Application Ref:	2025/0773			 Ribble Valley Borough Council www.ribblevalley.gov.uk				
Date Inspected:	30/10/2025	Site Notice:	30/10/2025					
Officer:	EP							
DELEGATED ITEM FILE REPORT:					APPROVAL

Development Description:	Proposed extensions and alterations to include two-storey front extension, single-storey rear extension, single storey link side extension adjoining proposed two storey garage with bedroom in roofspace and the construction of a new gated vehicular access and driveway.
Site Address/Location:	Hambledon View Clerk Hill Road Sabden Lancashire BB7 9DR.

DRAWING NO 004

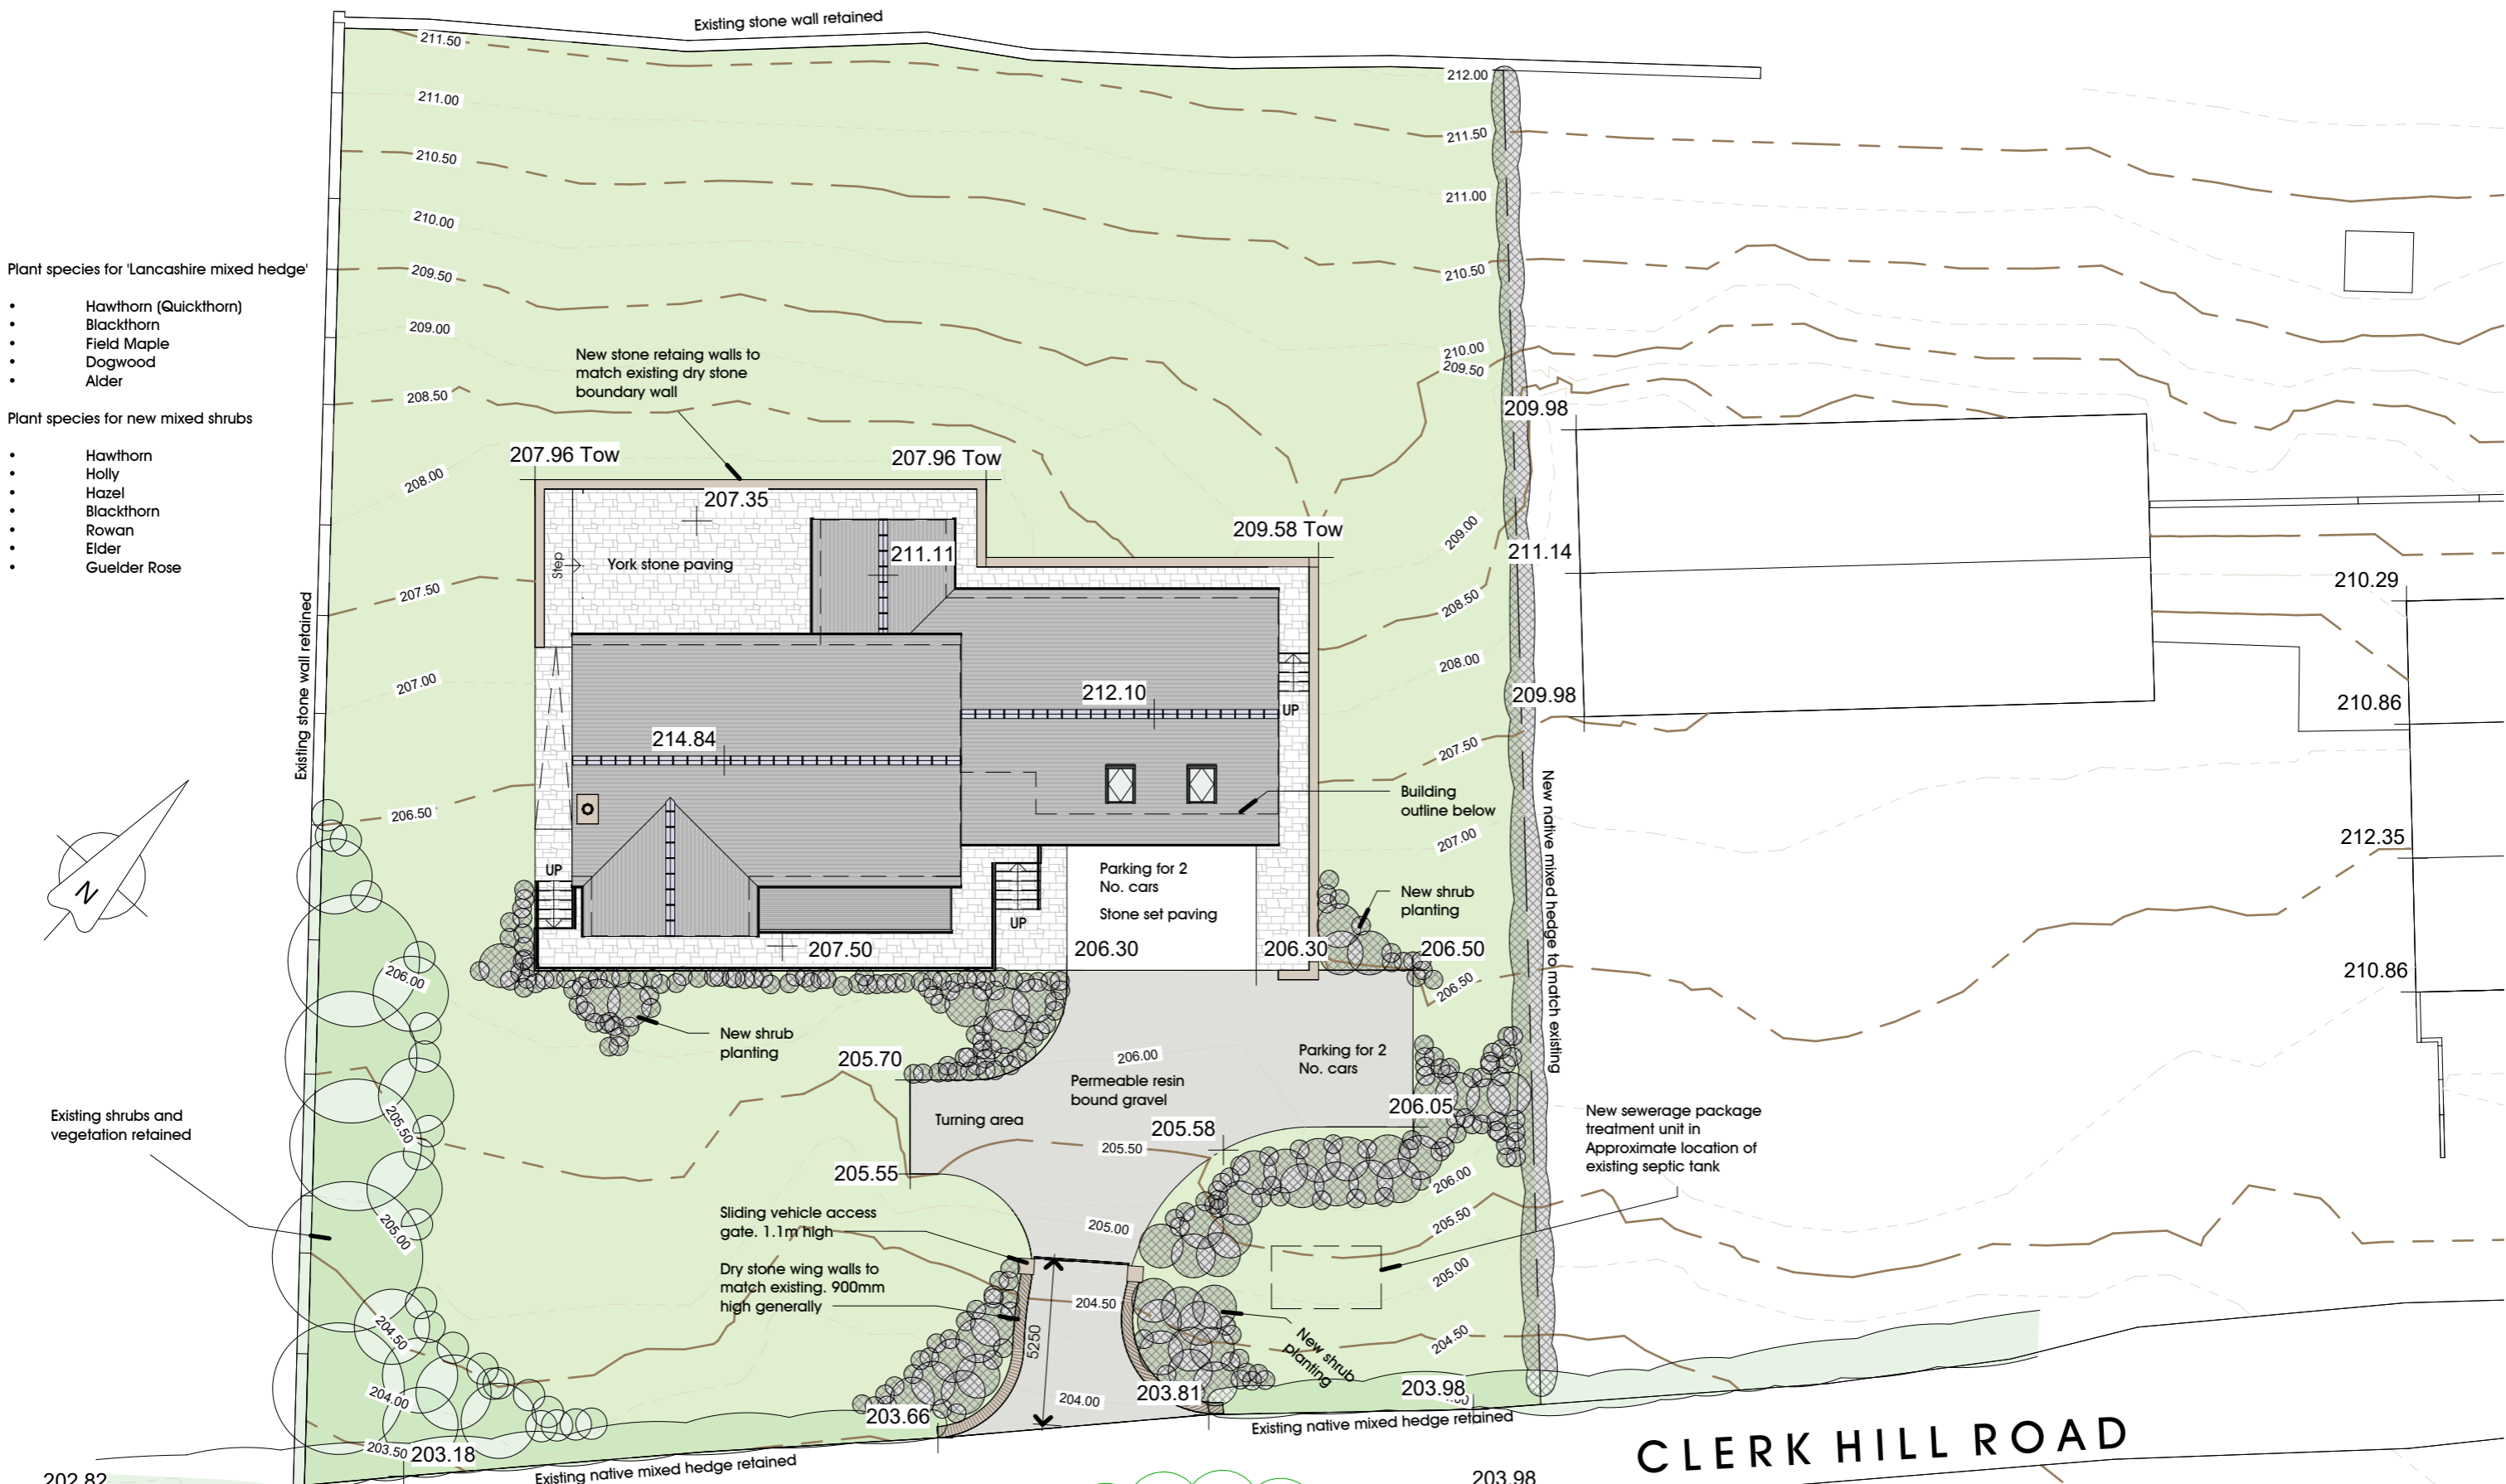
LCC Highways acting as the LHA has reviewed the proposed site plan drawing 004 and notes that there are acceptable off-street parking provisions considering the size and nature of the dwelling. There are also acceptable turning provisions that enable vehicles to enter and exit the site in a forward gear. On this basis, they raise no objection subject to the imposition of conditions relating to the construction and maintenance of the access and driveway.
